Please ask for: Ms Iqraa Malik
Email: iqraa.malik@terraquest.co.uk
Telephone: 01212341390
Our Ref: AW/38/21/HH
Your Ref:
Date: 9th February 2021

Application for Planning Permission for Works or Extension to a Dwelling

Development: Single storey rear infill extension, first floor side/rear extension, conversion of garage to habitable use, porch canopy to front with pitched roof and alterations to fenestration
Location: 4 St Richards Drive Aldwick PO21 3BH

Site Plan as proposed
1 : 200

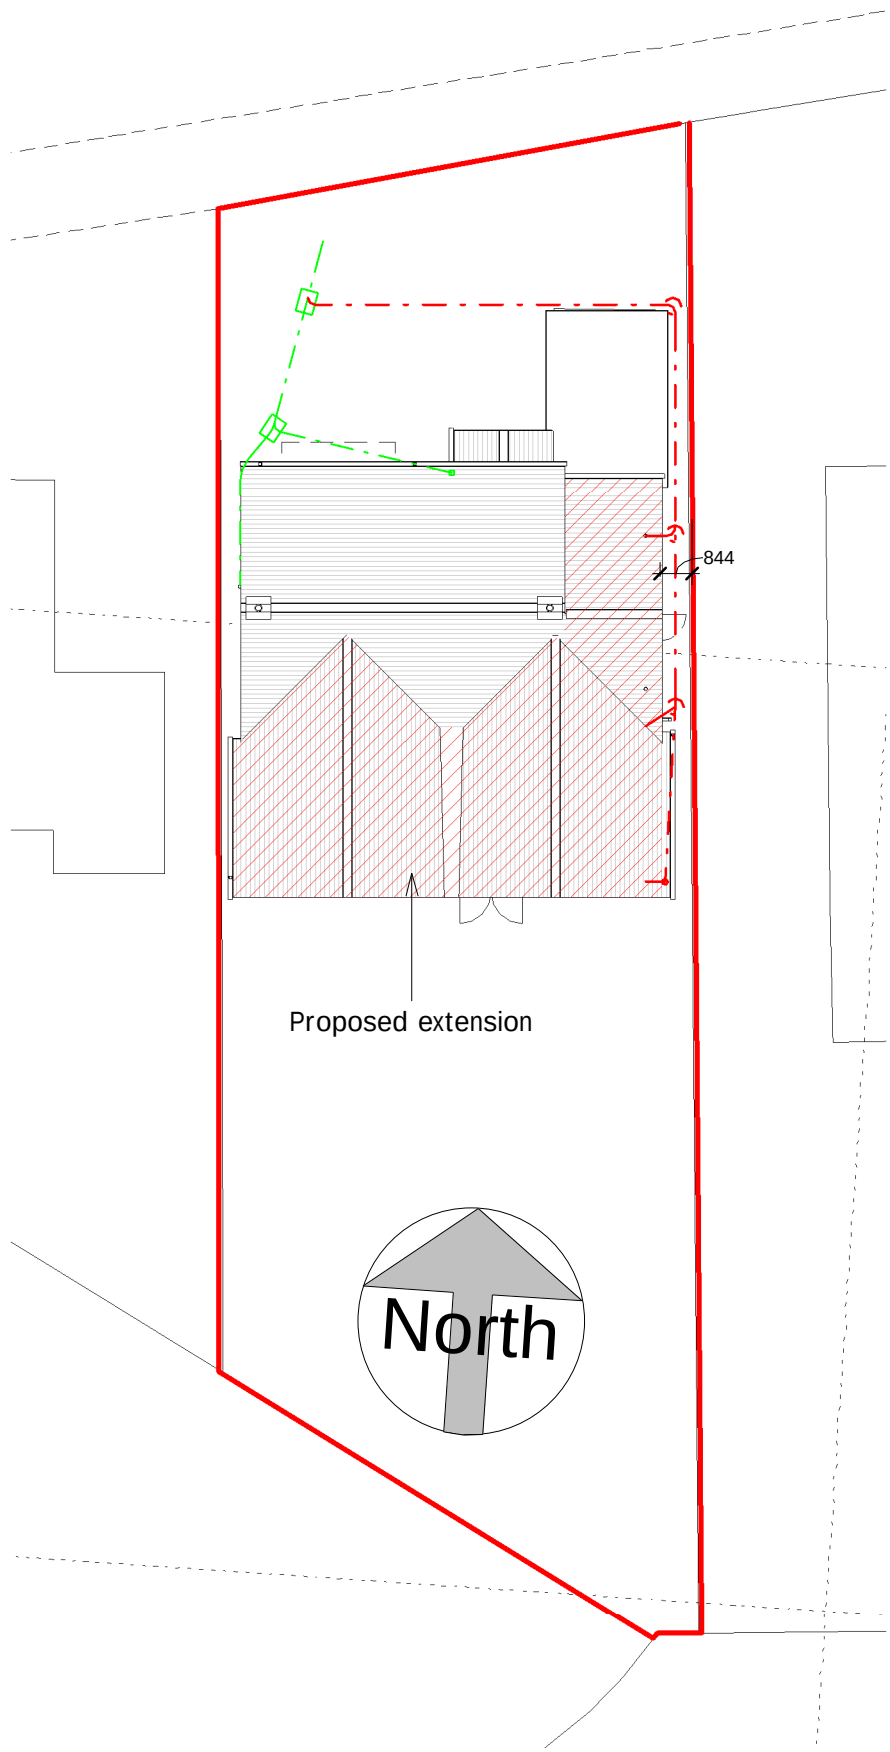
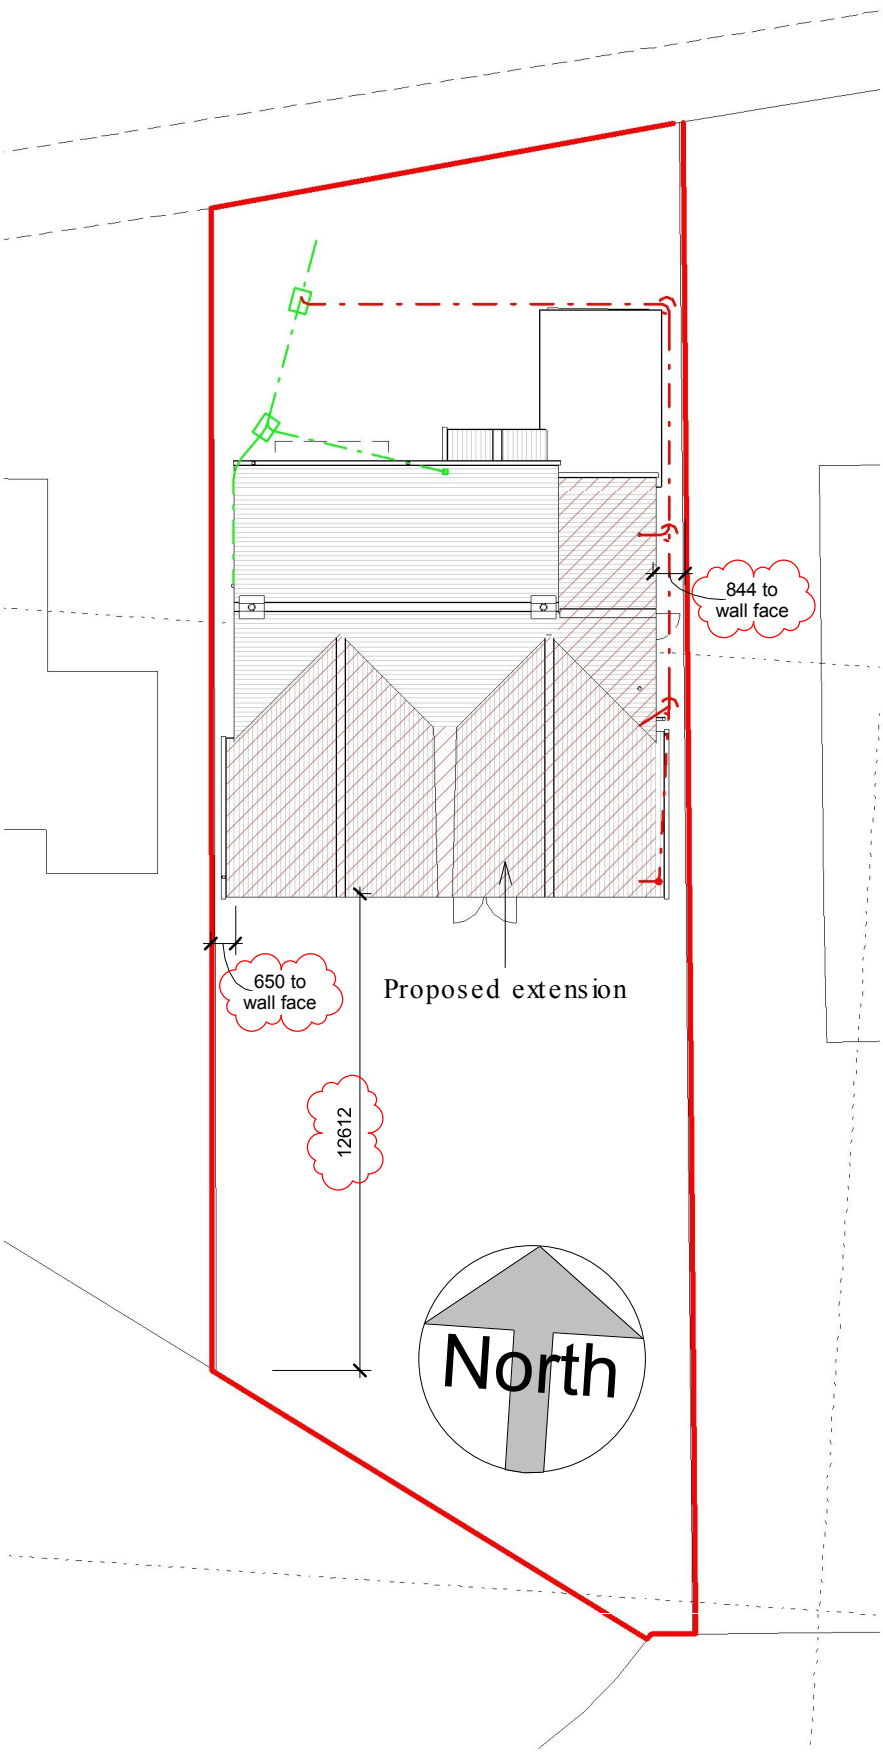
Dimensions: You are required to include dimensions on the block plan from the proposed extensions to all site boundaries. Please amend
